<b>Application Ref:</b>	2025/0228			 <div>Ribble Valley Borough Council</div> <div><a href="http://www.ribblevalley.gov.uk">www.ribblevalley.gov.uk</a></div>
<b>Date Inspected:</b>	12/03/2025	<b>Site Notice:</b>	N/A	
<b>Officer:</b>	EP			
<b>DELEGATED ITEM FILE REPORT:</b>				<b>APPROVAL</b>

<b>Development Description:</b>	Proposed raising of roof to accommodate a first-floor level. Two-storey side extension following demolition of existing single-storey side extension, insertion of ten rooflights and additional glazed openings.
<b>Site Address/Location:</b>	Stanacraft, Leys Close, Wiswell BB7 9DA.

SHEET:
PROPOSED ELEVATIONS

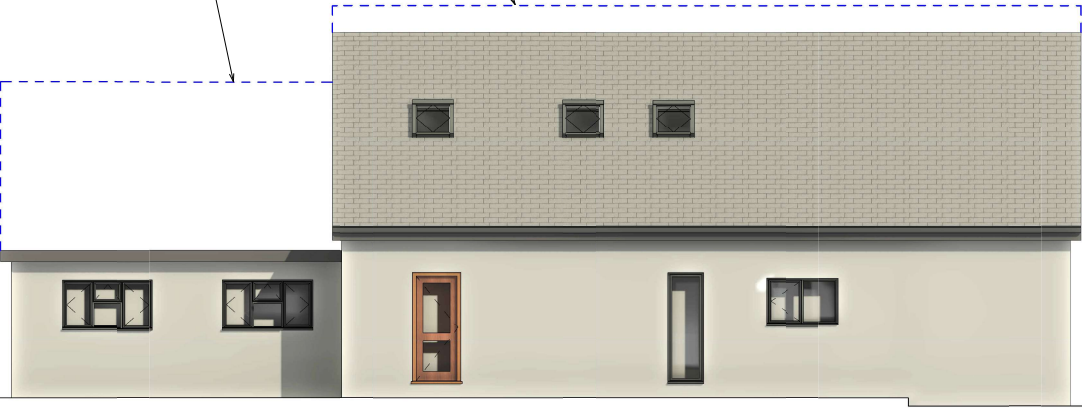
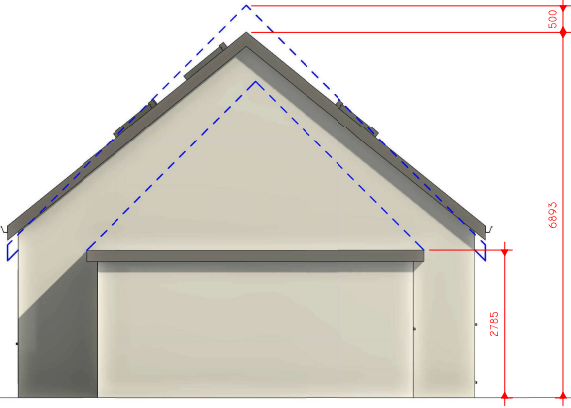
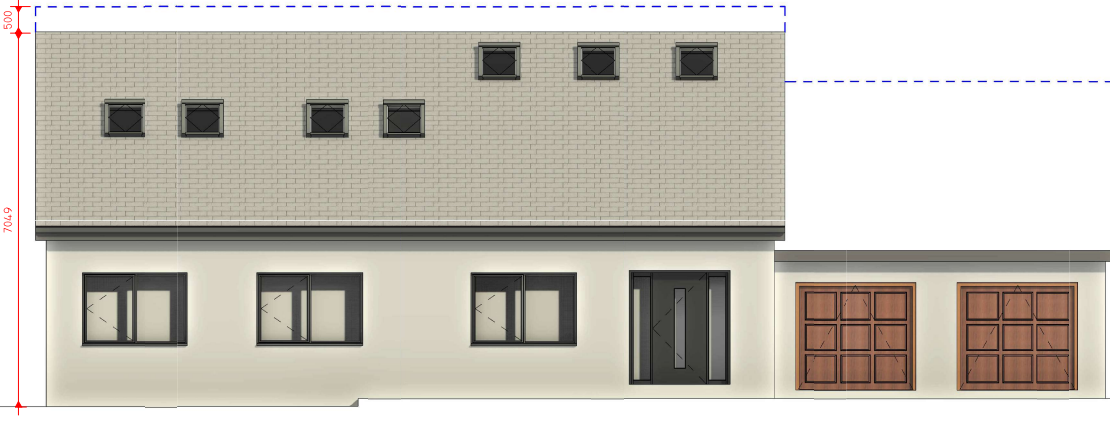
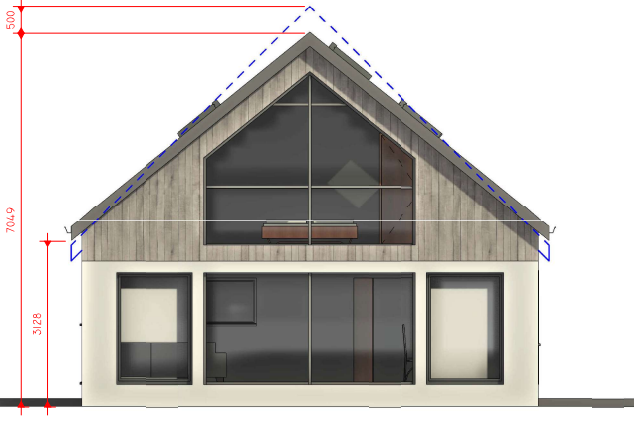
The application dwelling has two immediately adjacent neighbours known as Hollybank and 1 Leys Close. It is proposed that, by virtue of an additional storey, the roof of the application dwelling will be lifted. The main body of the roof, which currently measures approximately 5.6m in height to the ridge, will measure approximately 7m in height to the ridge. The existing dwelling also features a hipped roof, the proposal will have roof form that is flush with the gable.

Hollybank is located to the rear (north-east) of the application property. The proposed roof lift will result in an increase in height of approximately 1.4m. Whilst this may result in a small degree of light lost to private residential amenity space at Hollybank, it wouldn't be to a degree that would warrant refusal. Due to the position of the existing dwelling, the proposed roof lift would not result in any loss of light to habitable windows.

It is noted that there are concerns of the proposed new glazed openings on the north-west elevation of the application dwelling at first floor as it is deemed there is potential for overlooking into the front garden of Hollybank. It is recognised that there may be a slight increase in the perception of overlooking for the receptors of Hollybank. However, given the parcel of garden is located to the front of the curtilage and adjacent to the driveway, it is not considered that this area benefits from complete privacy as existing. Therefore, this alone would not warrant refusal. There are also concerns raised that the rooflights on the rear roof slope could create new opportunity for overlooking, this could be dealt with via an appropriate planning condition requesting obscure glazing and would therefore not warrant refusal.
